**Land To The South And Adj To South Side
Steeple Aston**

23/01852/DISC

Proposal: Discharge of condition 13 (landscaping details) of 19/02948/F

scheme: Land south of Southside, Steeple Aston, Oxon  
client: Rectory Homes  
drawing: Soft Landscape  
date: Apr. 2021  
scale: 1:250@A1  
drawing no: REC23270-11B  
drawn: JNT checked: JS

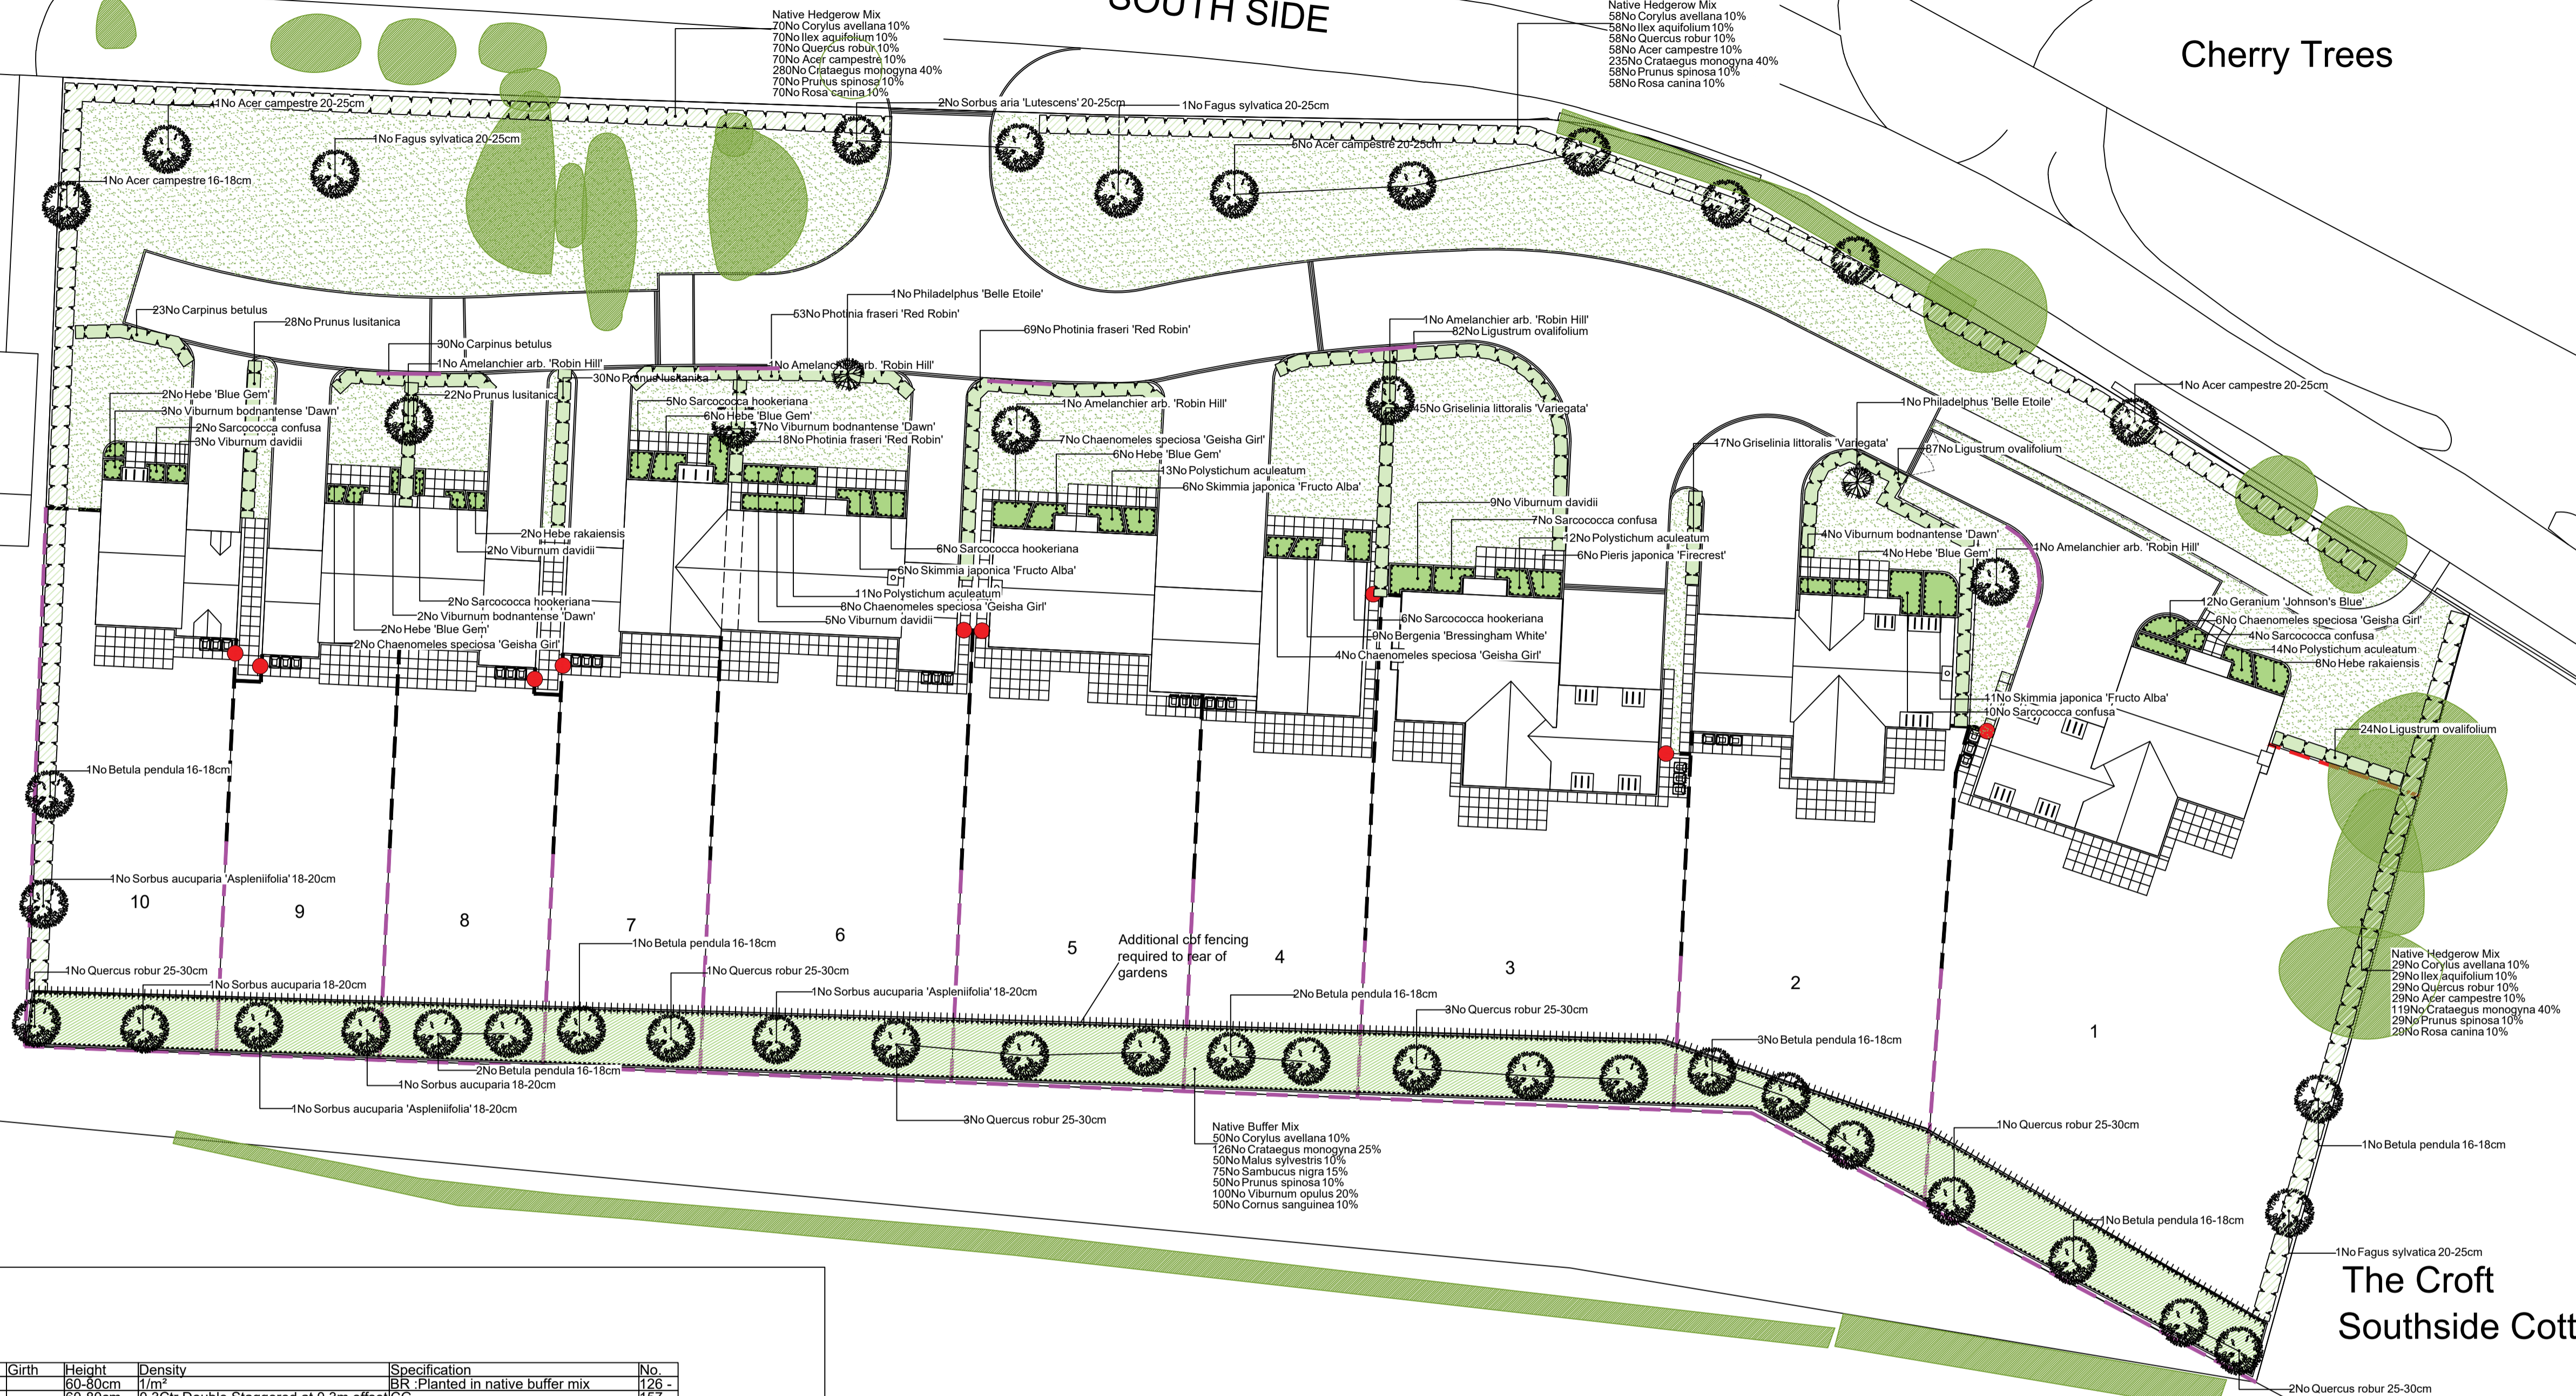
- Replace the 1.2m high estate railings proposed along the footpath north of Plot 1 to 1.2m high post and rail fencing
- Omission of the hedge between the footpath north of Plot 1 and the driveway
- Deletion of the 1.2m high estate railings proposed to define the front curtilage between plots 1 and 2 and replace with a hedge
- Planting of a new hedge along the boundary treatment to the east of Plot 1

The applicant has advised that the hedge originally proposed between the footpath and the driveway has been removed due to insufficient space between the fencing and curblin.

The post and rail fence reverts back to the boundary treatment originally approved under 19/02948/F.

It is considered that these amendments to the approved scheme do not result in any substantial changes and whilst it is unfortunate that the estate railings would be omitted from the scheme the amended details do not adversely affect the visual appearance of the development to any significant degree.

- Soft Landscaping Plan - REC23271-11 Rev B
- Soft landscaping management and maintenance plan – REC 23271-11 Rev A
- Materials and boundary treatments plan – T.224.01.501 Rev A
